July 31, 2022

Reference: Engineering Services
Walker Rd. – Lot 3
724 Walker Rd.
Bunn Level, NC 28323
TE&D Project No.: 2201-020538_A

As requested, a representative of Tyndall Engineering & Design, PA (TE&D) was on-site to observe the following items:

Foundation Plan

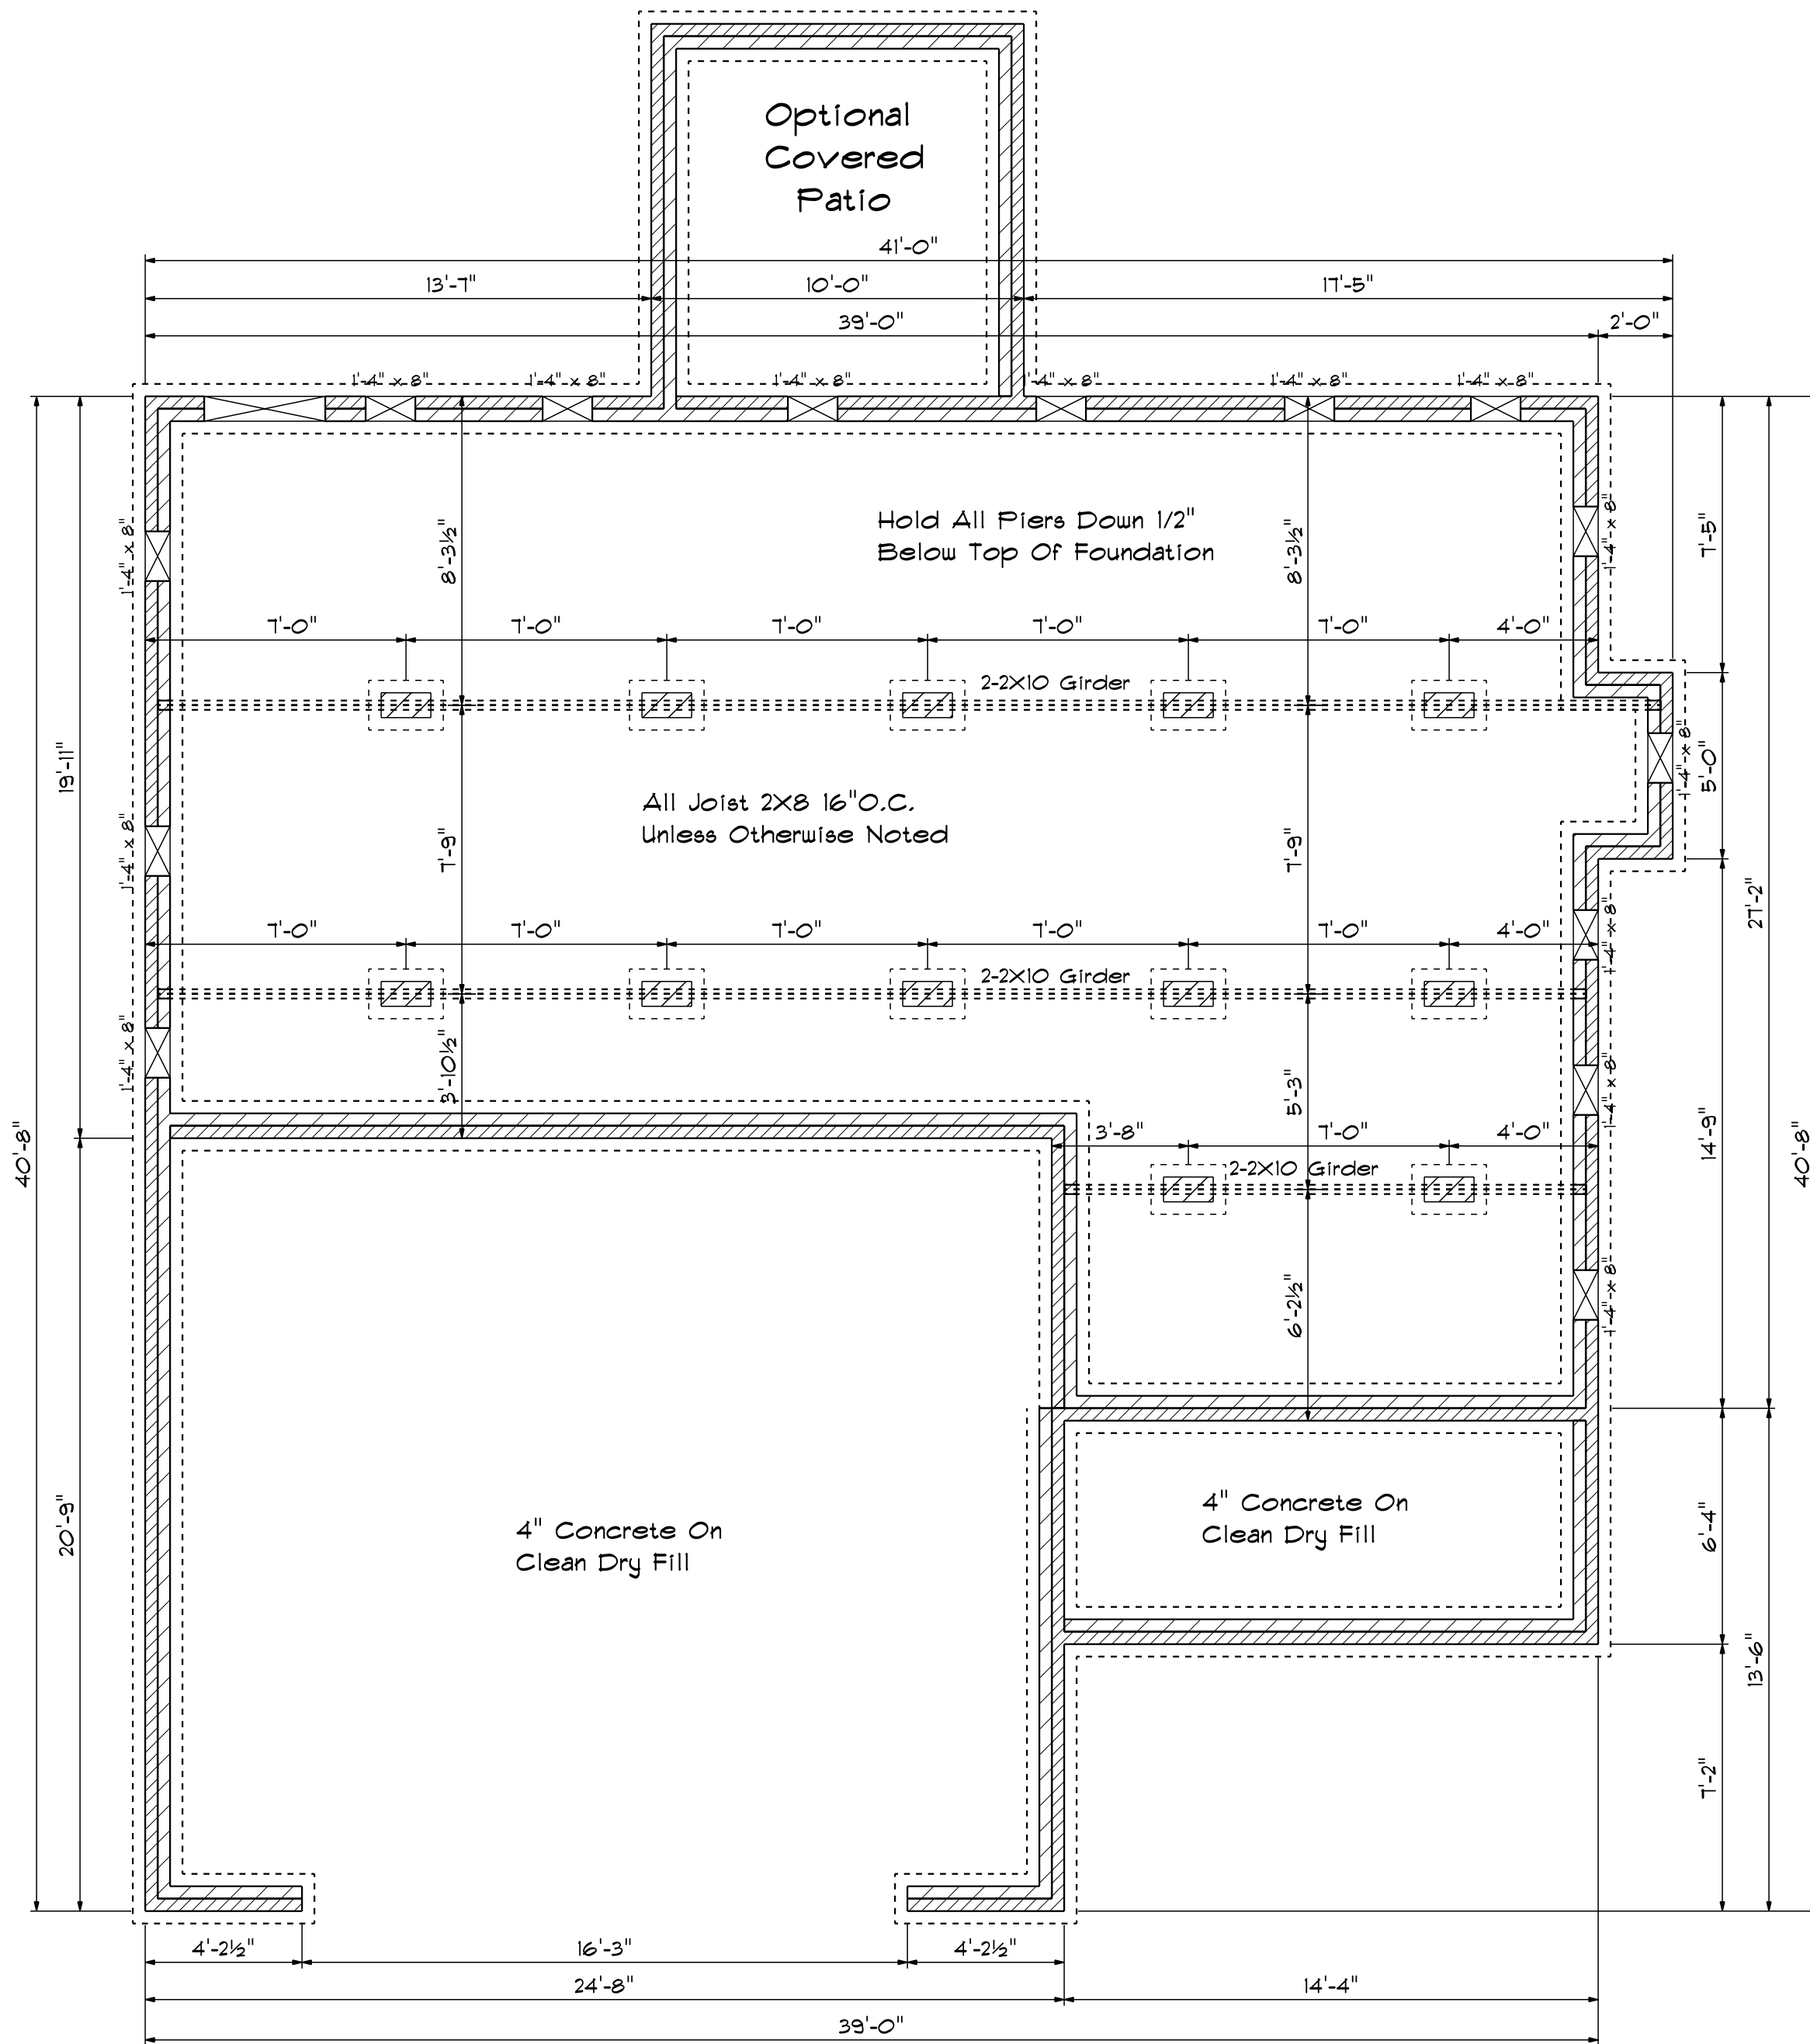
- 1) We observed a new 4 x 8 pilaster was installed for girder support. The construction of the pilaster in regards to the footing and tie in to the foundation was unknown to TE&D. The (2) 2 x 10 girder extended into the pony wall and was supported with (2) 2 x 4 jacks and (2) 2 x 4 king studs. The girder was notched to accommodate for the pony wall top plate. Based on our observations and analysis, the existing girder requires modification. The girder is to be increased to a (4) 2 x 10 girder from the adjacent pier to the pony wall. The new plys are to be added on each side and fastened with (3) rows of 16d nails at 4" o.c. New plys may be notched at the pony wall. The entire new girder is to be supported with (4) 2 x 4 jacks and (2) 2 x 4 kings at the pony wall. The pilaster is not providing significant structural support to the girder and may remain or be removed if required.

- 2) We observed a new 4 x 8 pilaster was installed for girder support. The construction of the pilaster in regards to the footing and tie in to the foundation was unknown to TE&D. The (2) 2 x 10 girder extended into the pony wall and was supported with (2) 2 x 4 jacks and (2) 2 x 4 king studs. The girder was notched to accommodate for the pony wall top plate. Based on our observations and analysis, the existing girder remains suitable to support the anticipated loading conditions. The existing jacks are to be removed and replaced with tightly fitting members. The pilaster is not providing significant structural support to the girder and may remain or be removed if required.

- 3) We observed a new 4 x 8 pilaster was installed for girder support. The construction of the pilaster in regards to the footing and tie in to the foundation was unknown to TE&D. Bearing of left end of middle girder. We also observed the girder was supported with a (3) 2 x 6 dropped header. Based on our observations and analysis, the existing girder and supporting framing remains suitable. No structural modification required. The pilaster is not providing significant structural support to the girder and may remain or be removed if required.

- 4) We observed a new 4 x 8 pilaster was installed for girder support. The construction of the pilaster in regards to the footing and tie in to the foundation was unknown to TE&D. The (2) 2 x 10 girder extended into the pony wall and was supported with (2) 2 x 4 jacks and (2) 2 x 4 king studs. Based on our observations and analysis, the existing girder remains suitable to support the anticipated loading conditions. The pilaster is not providing significant structural support to the girder and may remain or be removed if required.

- 5) We observed a new 4 x 8 pilaster was installed for girder support. The construction of the pilaster in regards to the footing and tie in to the foundation was unknown to TE&D. The (2) 2 x 10 girder extended onto the pilaster; however, did not have full bearing. Based on our observations and analysis, the existing girder requires modification. The girder is to be increased to a (4) 2 x 10 girder from the adjacent pier to the pony wall. The new plys are to be added on each side and fastened with (3) rows of 16d nails at 4" o.c. Due to the minimal imposed load to the pilaster, the existing pilaster remains suitable as constructed.

- 6) We observed a new 4 x 8 pilaster was installed for girder support. The construction of the pilaster in regards to the footing and tie in to the foundation was unknown to TE&D. The (2) 2 x 10 girder extended onto the pilaster; however, did not have full bearing. Based on our observations and analysis, the existing girder requires modification. The girder is to be increased to a (4) 2 x 10 girder from the adjacent pier to the pony wall. The new plys are to be added on each side and fastened with (3) rows of 16d nails at 4" o.c. Due to the minimal imposed load to the pilaster, the existing pilaster remains suitable as constructed.

Item #1 – New plys to be added to each side of girder

Item #2 – Jacks to be installed tightly

Item #3 – Girder remains suitable

Item #4 – Girder remains suitable

Item #6 - New plys to be added to each side of girder

Item #7 - New plys to be added to each side of girder
